Response to Planning Application

Application ref: LU/83/25/OUT

Description: Outline planning application (with all matters except access reserved) for the construction of 31 No. residential units. This application is in CIL zone 2 (CIL liable) and may affect the setting of listed buildings.

Location: Westholme Nursery Toddington Lane Littlehampton BN17 7PP

Fig. 3: Proposed Site Plan
(Provided by Client)

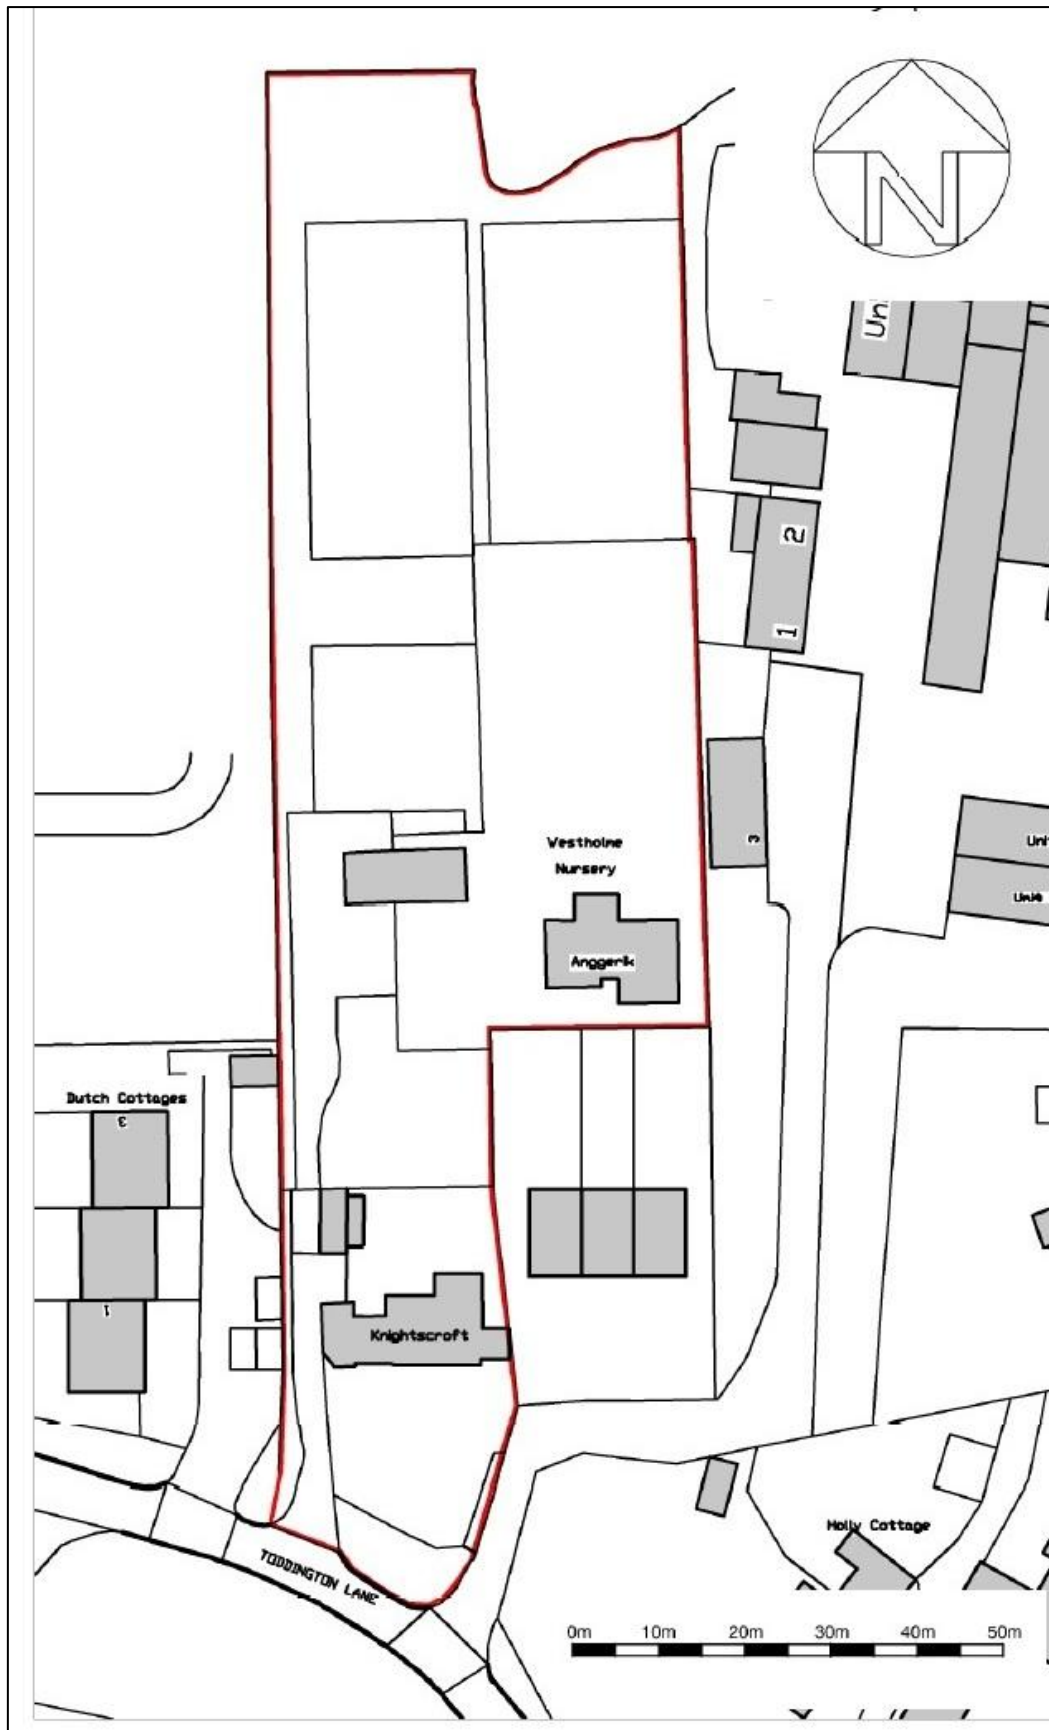
The application states that matters of scale, layout, landscaping and appearance would be reserved for subsequent determination, with the application supported by a number of proposed **indicative drawings**, including the Proposed Site Plan (Drawing No. TA 1057 / 10 Rev. A), which details how the proposed 31 units, access road, car parking space, amenity space and landscaping may be delivered on the site. It should be noted that whilst the landscape detail has been suggested to be determined under reserved matters however **the layout shown would not appear to meet SPD requirements for POS provision as outlined in our ADC SPD Open Space, Playing Pitches, Indoor and Built Sports Facilities January 2020.**

The layout proposed appears to fall short of the POS provision required and therefore should be raised as an objection. The proposals have not incorporated play in the form of LAP provision which would be a requirement of the development.

The layout of the proposals show a densely packed site with little space for green infrastructure to be incorporated. Communal open space provision would also need to conform to the Arun Design Guide 2021.

The layout would need to further detail the SuDS provision within the development. SuDS are required to be fitting with the development and well designed to be an asset to the site, to provide interest, visually and biodiversity enhancement.

A full and detailed landscape scheme will be required to be submitted for approval, detailing species choice, quantities, planting densities and size at time of planting. This should be plotted in plan and list form and in relation to the trees and vegetation to be retained so that a clear picture of the proposals can be seen. These details are required to ensure that appropriate screening is provided, maintaining and uncompromising the setting and ensuring that the proposals fit within the area of neighbouring properties, providing screening as required, increasing biodiversity and wildlife habitat.
